Able - Proposed MEP, Killingholme

Associated British Ports (10015525)

Summary of Oral Representations by Associate British Ports at Marine Hearing

13th September 2012

Figure N1.9 Proposed disposal sites in the Humber Estuary (©OS OpenData™),)

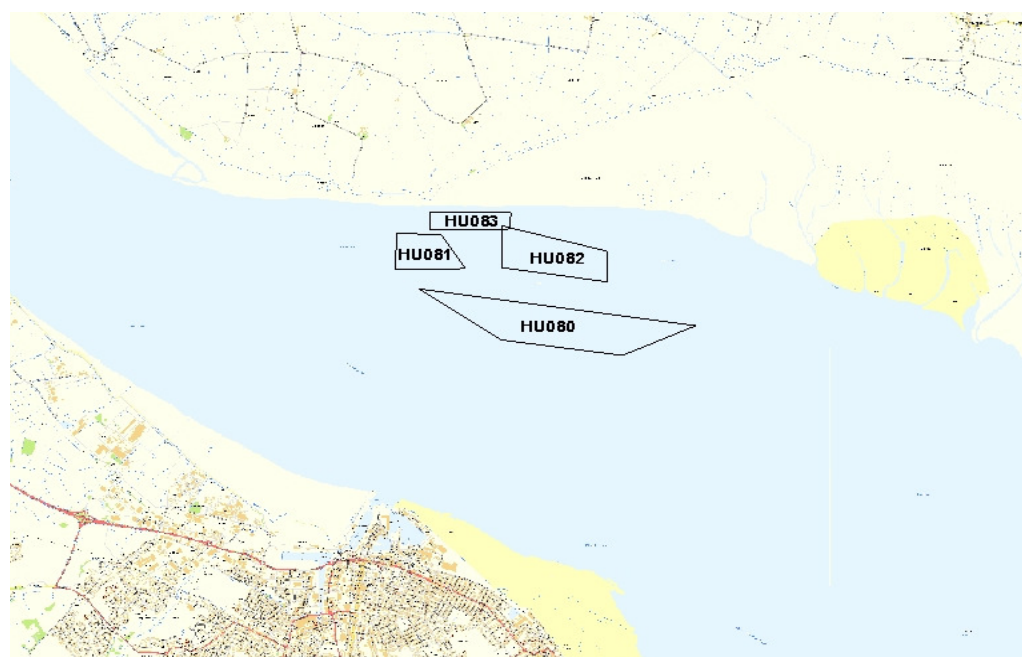
- 3.1. As regards the disposal of dredged material (capital and maintenance), ABP raised concerns about the choice of HU080 as the proposed deposit ground for erodible material. Such concerns arise due to the following:

- I. The material (particularly with respect to the maintenance dredge arisings) would be transferred from the middle to the lower estuary, where a greater proportion will be lost from the system, thereby affecting the sediment balance of the estuary in the longer term;

- II. Also, finer sediment would be distributed to an area where generally sandier sediment dominates, in such a way as is likely to have an impact on the local benthos in a European designated SAC. Generally, in the designation of deposit grounds there is normally a presumption in favour of depositing sediments of like character to the bed material at disposal sites in the Humber where possible;

- III. The additional supply of sediment to the water column from the dispersal of the deposits at HU080 would effectively raise the supply of sediment available for sedimentation within the Sunk Dredged Channel (SDC). This would increase the potential interference for navigation through the (SDC) at times of high sedimentation in the cyclic pattern which hitherto has occurred in the channel. At present the channel is self-maintaining and has scoured to the underlying resistant boulder clay bed. A similar situation occurred at the

beginning of the 1980's, where no maintenance dredging was required. In 1996/7, however, settlement from the water column, along with bed movement caused rates of sedimentation with which two dredgers working together could not keep pace. This caused navigation restrictions through the channel. Should/when such a pattern of sedimentation returns to the SDC the additional maintenance arisings from AMEP will add to the 'pool' of available sediment, increasing sedimentation rates to greater than occurred in 1996/7. Considerable development has been undertaken since the difficulties of 1996/7, so that the channel now also services the berths at HIT. As such, any potential restriction would have greater consequences on the navigation to the channel than previously. **This issue has not been assessed in the ES, therefore any monitoring and mitigation have not been proposed.**
